CITY OF ALBUQUERQUE

March 27, 2017

**RE: TLC Plumbing Office/Warehouse
Grading Plan and Drainage Report
Stamp Date: 2/24/17
Hydrology File: G15D032**

TLC OFFICE WAREHOUSE - NORTH BOUNDARY ONSITE SWALE

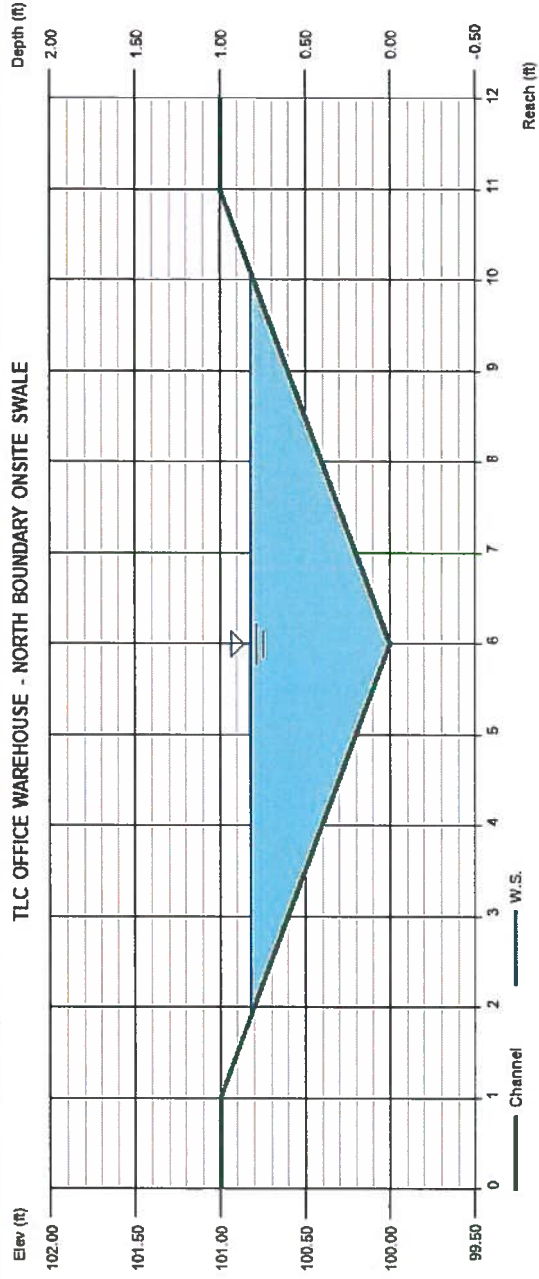
1. Please show a cross section for Sub Basin 100 and label the size and depth of the rock for the drainage swale.
